Scales: 1:50 1:200
No: 2386/01/12

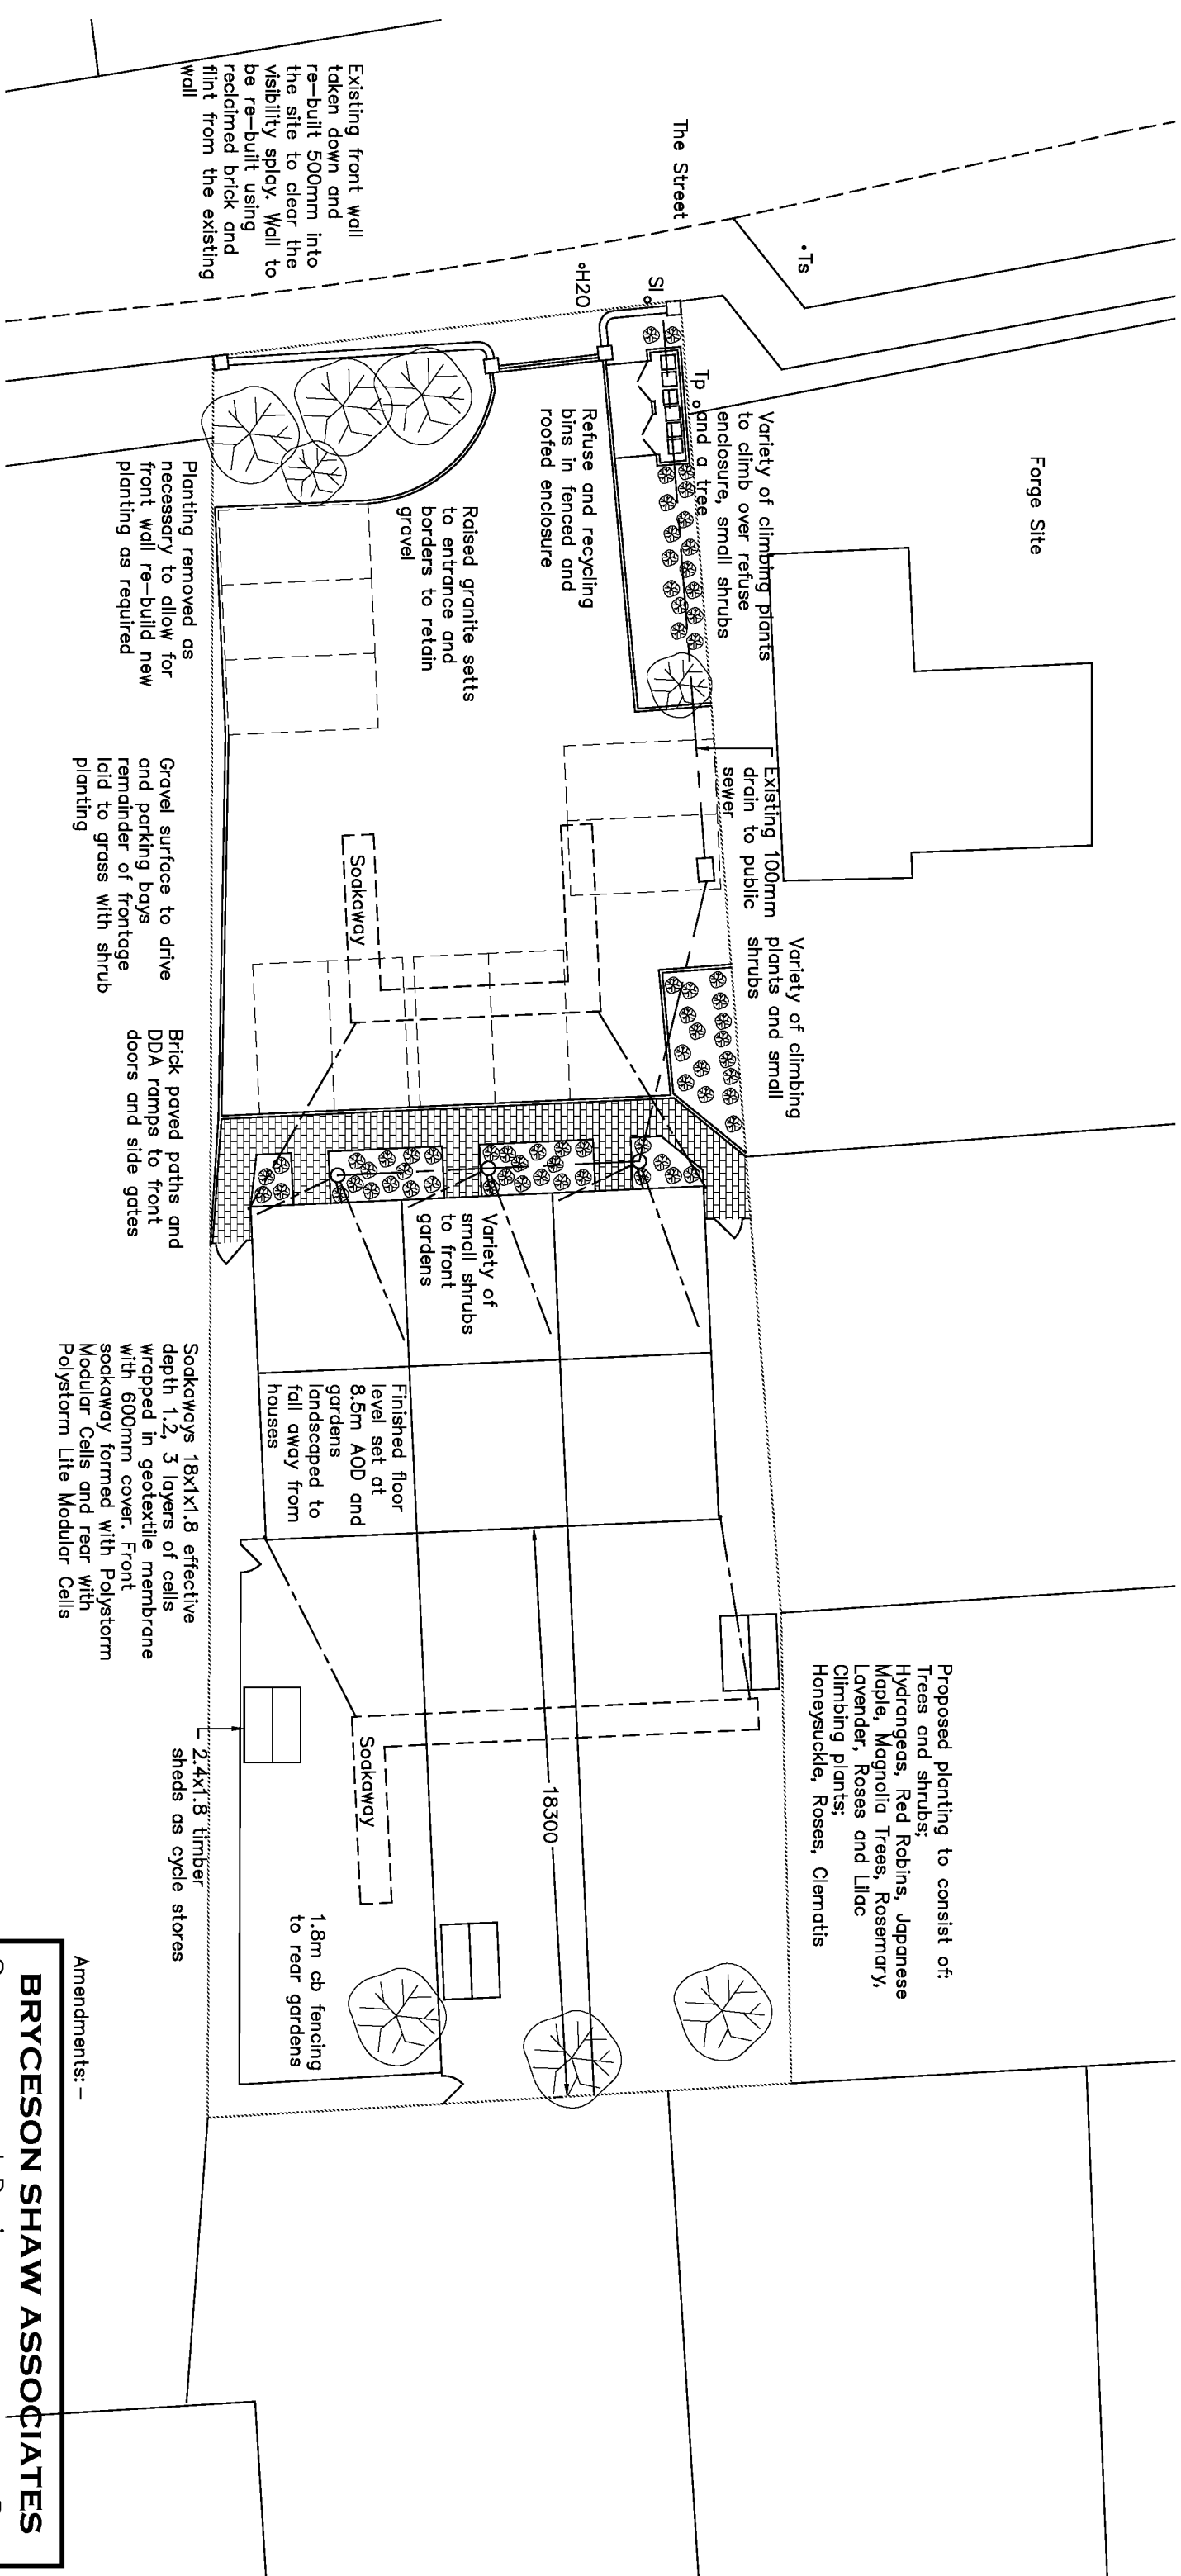
I have been allocated the above application and am carrying out the relevant consultations with other departments. However in the meantime I note that the information submitted with regard to discharge of conditions 8 -hard & soft landscaping and 10 - existing wall to south, lack sufficient detail at this stage. I will require confirmation of pot and plant sizes and plant numbers and details of replacement planting for the existing front border where the wall is being demolished and details of tree hedge retention and protection. For the walling the condition requires details of method of demolition and rebuilding. I would suggest that photographs of the existing wall are provided as a reference point and that an elevation of the proposed replacement wall is provided to detail how existing bricks and flints will be reused together with the type of mortar and amount of protrusion of flintwork from cement.

I attached revised copies of drawings .../03D and .../12 with the altered parking space positions and the front garden wall re-building details together with clear photos of the wall. The wall is too overgrown to be clearly visible at the moment.
